**KIRKLEES METROPOLITAN COUNCIL
INVESTMENT & REGENERATION SERVICE**

**DELEGATED DECISION TO DETERMINE APPLICATIONS FOR
CONSENT, AGREEMENT OR APPROVAL REQUIRED BY CONDITION**

Reference No:	2021/44/94639/E
Site Address:	Former North Bierley Waste Water Treatment Works, Oakenshaw, BD12 7ET
Description:	Discharge of condition 19 (Public Right of Way) of previous outline permission 2016/92298 for redevelopment of former waste water treatment works following demolition of existing structures to provide employment uses (use classes B1(c), B2 and B8)
Recommending Officer:	Nick Hirst

Condition 19 (Public Right of Way)

Dig Title: PROW LAYOUT

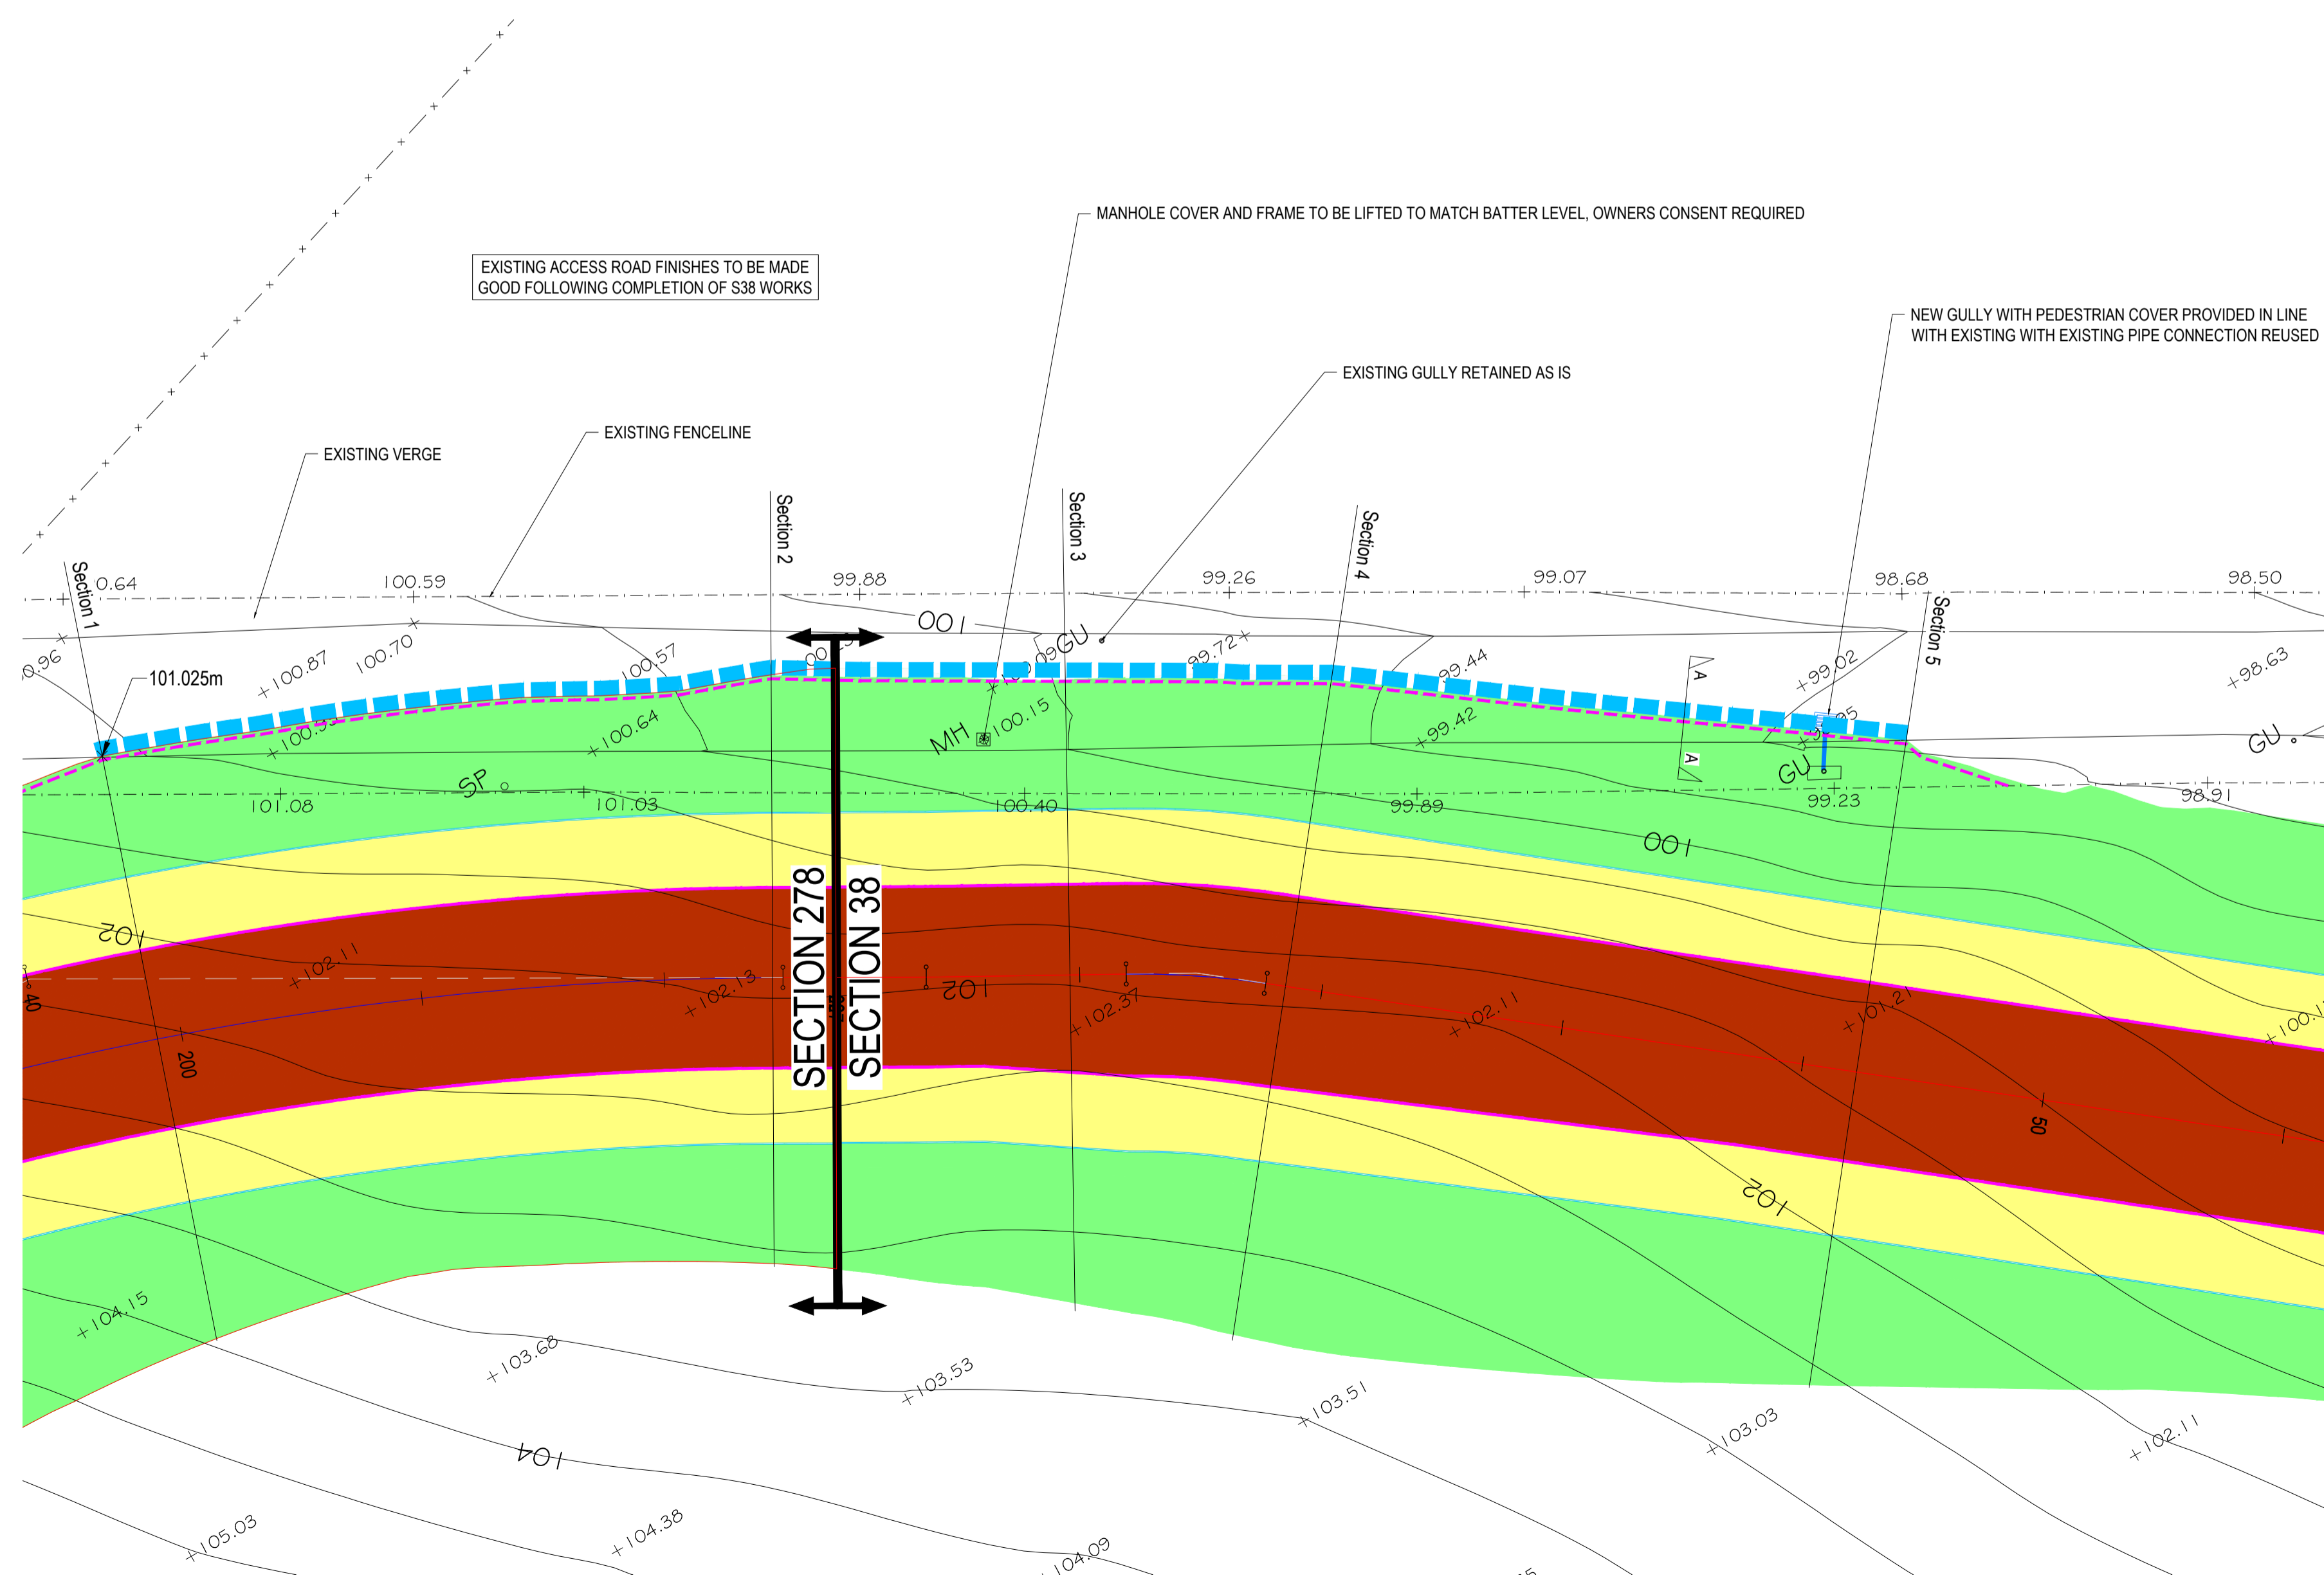
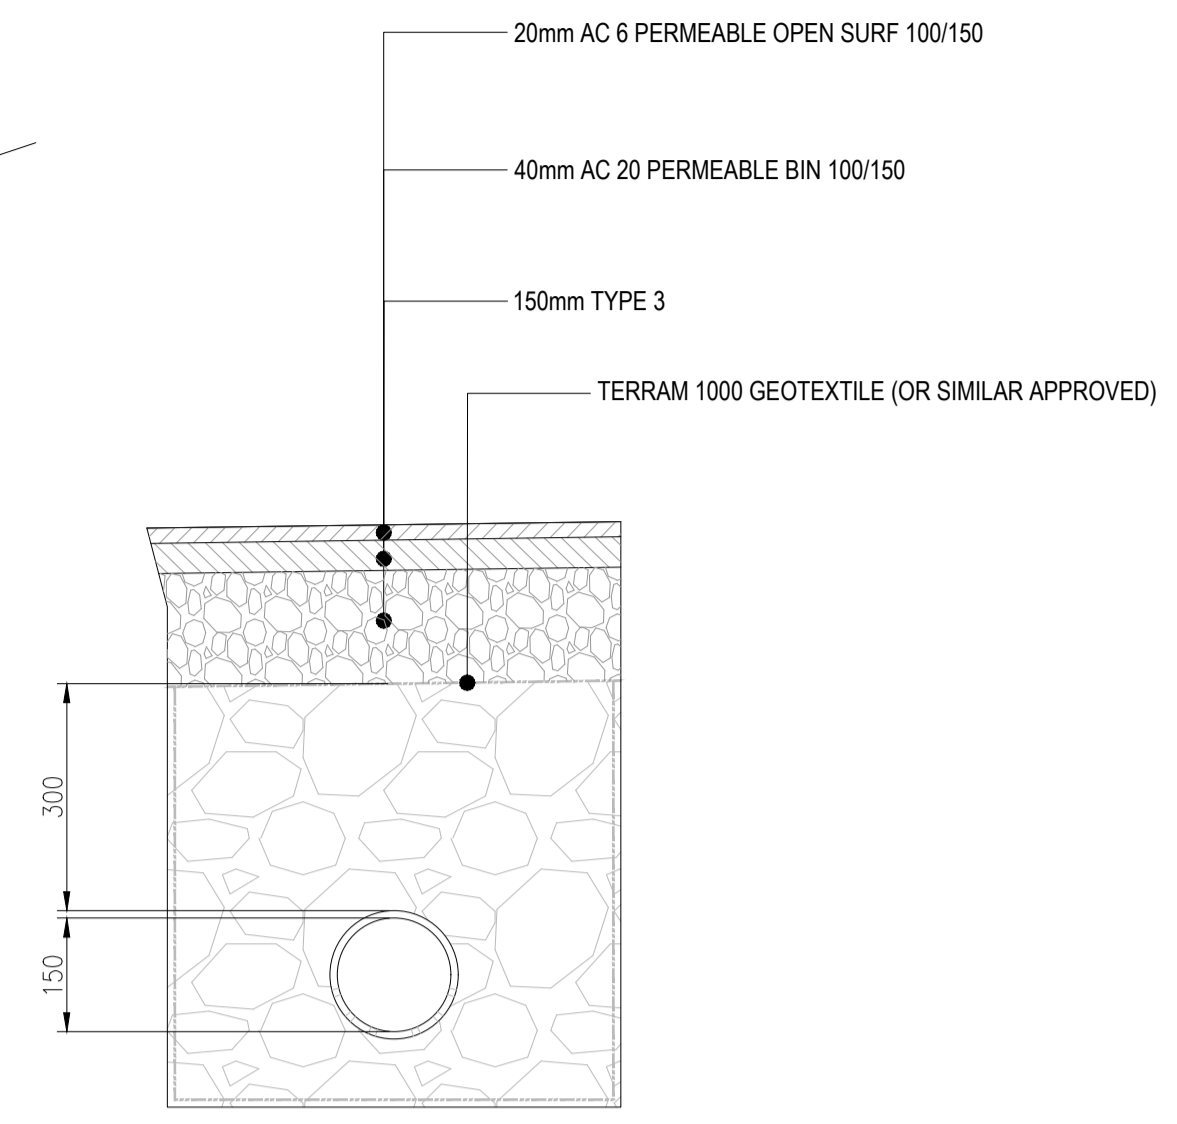
The PROW is the site's former main access for vehicles and has a recorded width of 2.0m, although the original road is wider than this. Due to the route and proximity of the site's new access road, for 90m the width of the current road is

to be reduced to facilitate the road's batter. This includes a circa 30m section where the width of the PROW would be 1.8m, below the 2.0m recorded width. Section plans of this arrangement have been provided. The need for this has been justified by the applicant on engineering grounds to facilitate the delivery of the new access road.

The existing fence line along the north of the PROW is to be retained, with a post and rail fence (shown within the supporting document) provided along the south side.

PROJECT:	PROPOSED DEVELOPMENT INTERCHANGE 26 CLECKHEATON		
TITLE:	PROPOSED SITE LAYOUT PROW		
DRAWING NO:	1856 PL 159 (C)		
BY/CHECKED:	DPE	DATE:	SEPT 2020
SCALE @A1:	1:500 (1:1000 @ A3)		
Tower Works, Globe Road, Leeds, LS11 5QG Tel: 0113 3453590 E-mail: info@ellishealey.com

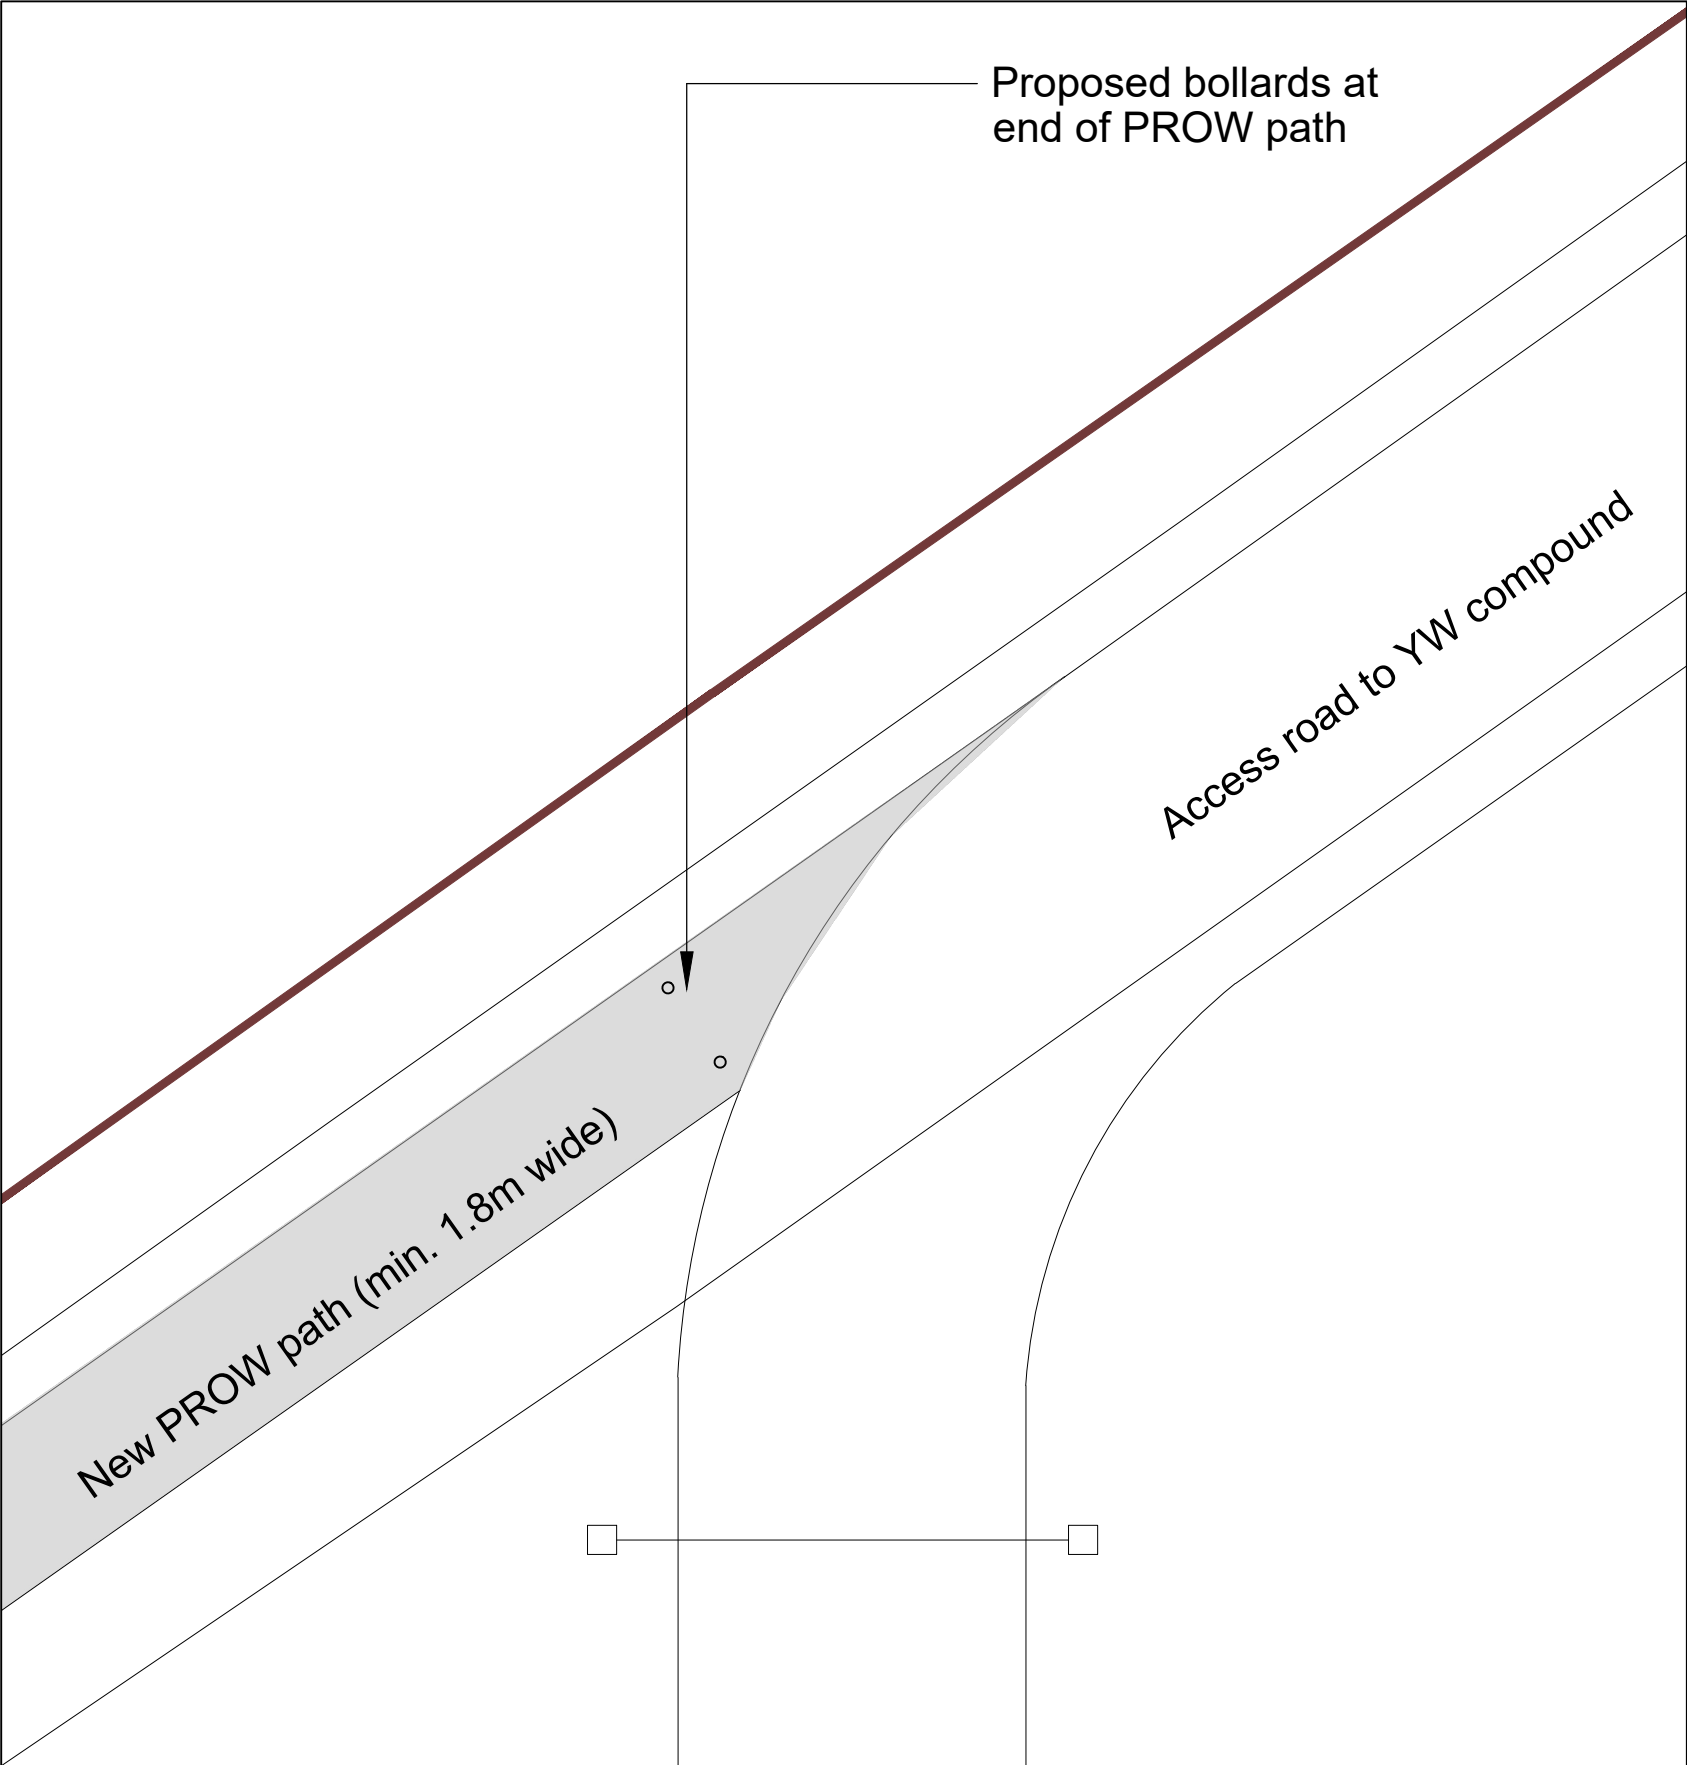
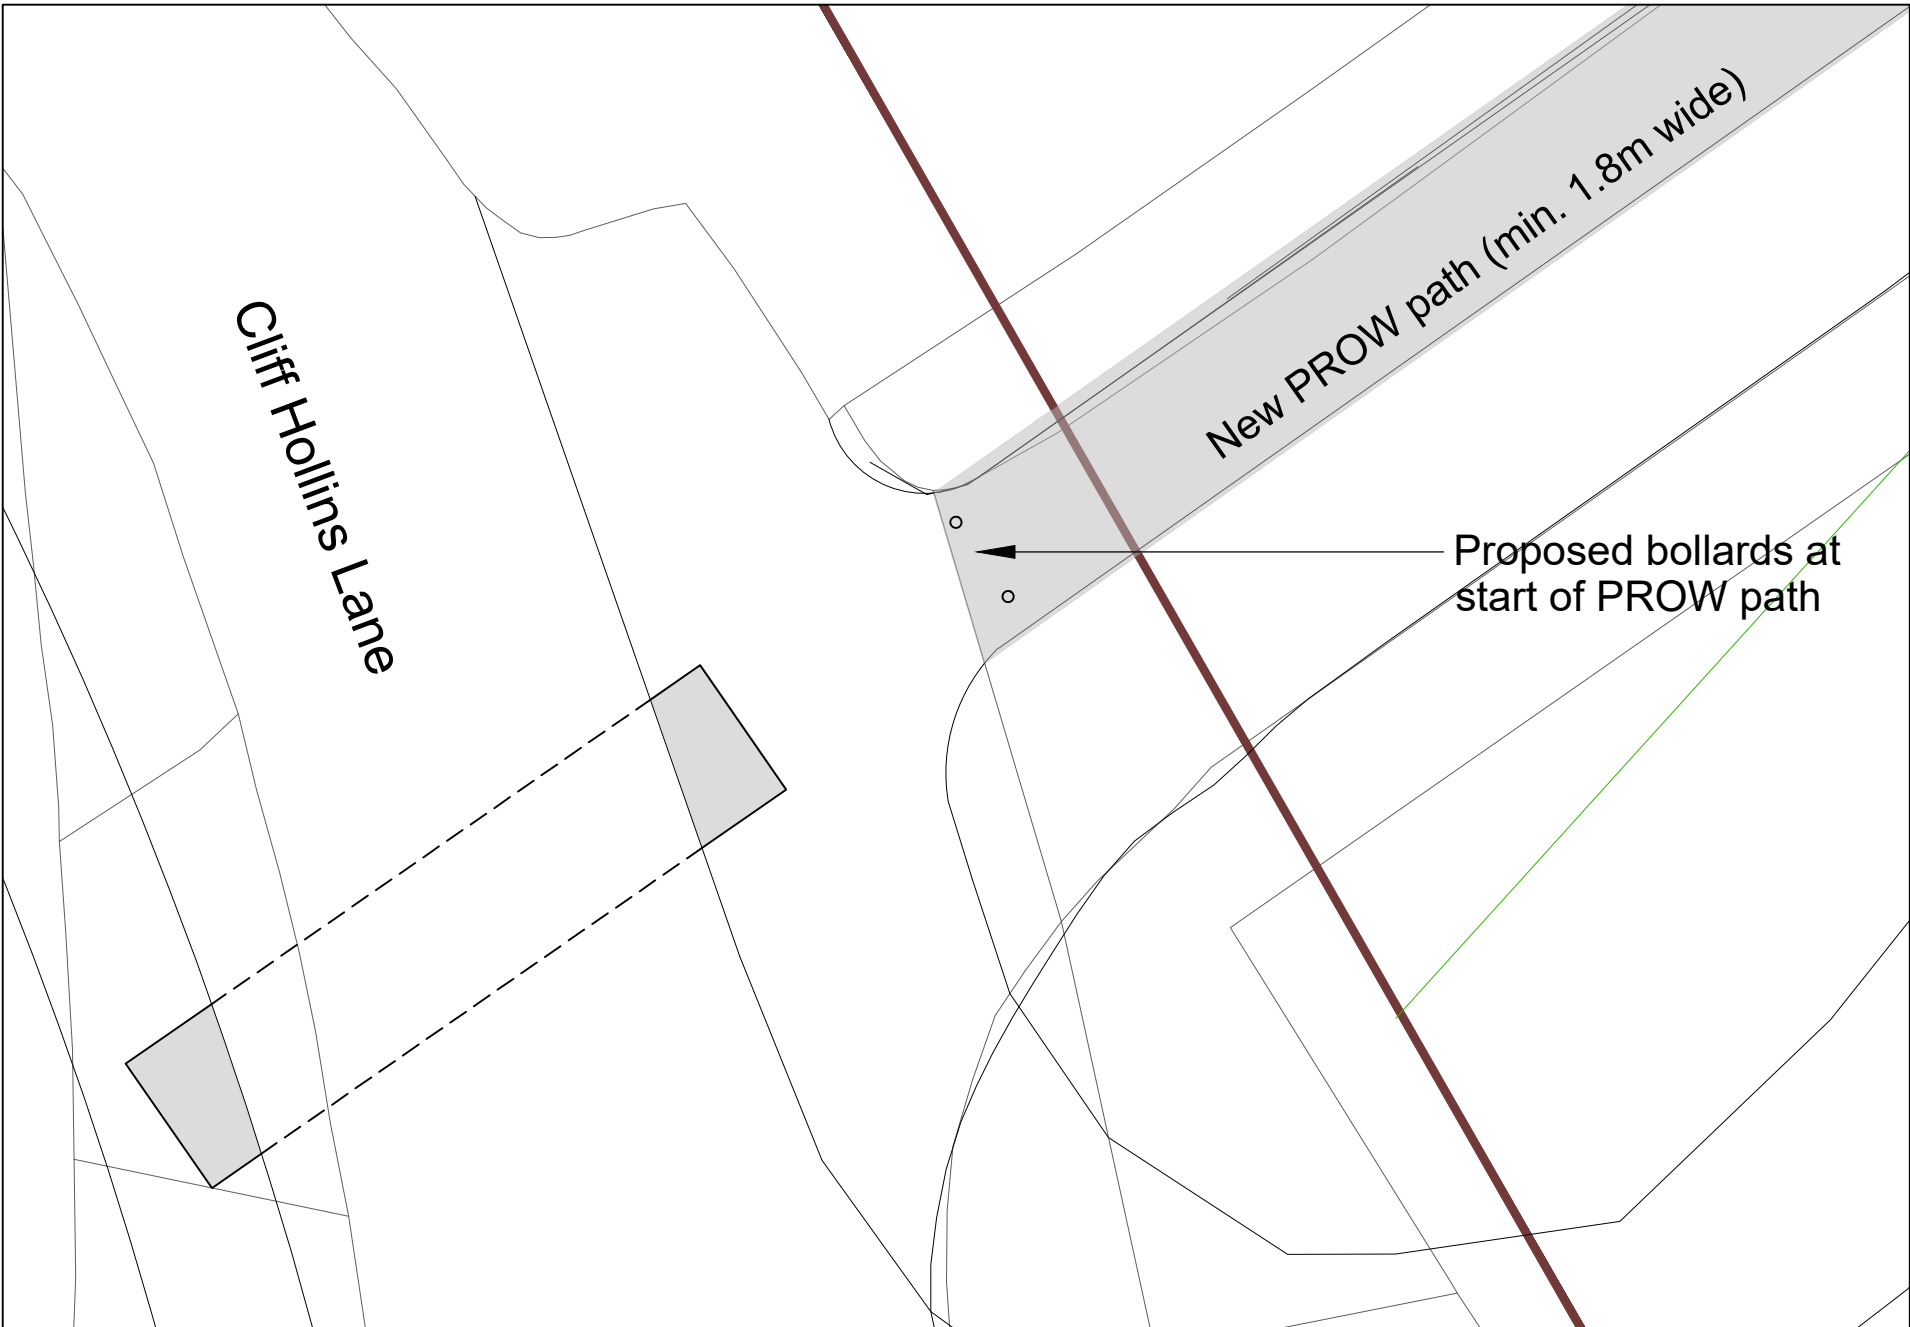
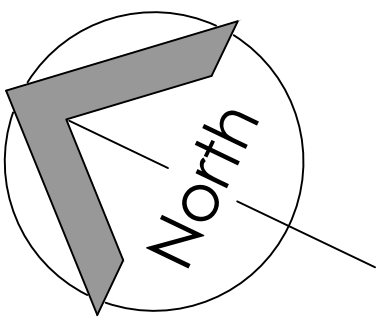
The submitted details are considered acceptable for the initial purpose of condition 19. For the avoidance of doubt this includes (but is not limited to) the provision of bollards, which is not specifically noted within plan ref: 798/LA2H

but is clearly shown on plan ref: 1856 PL 159 rev C and detailed within the email dated 17/07/2023.
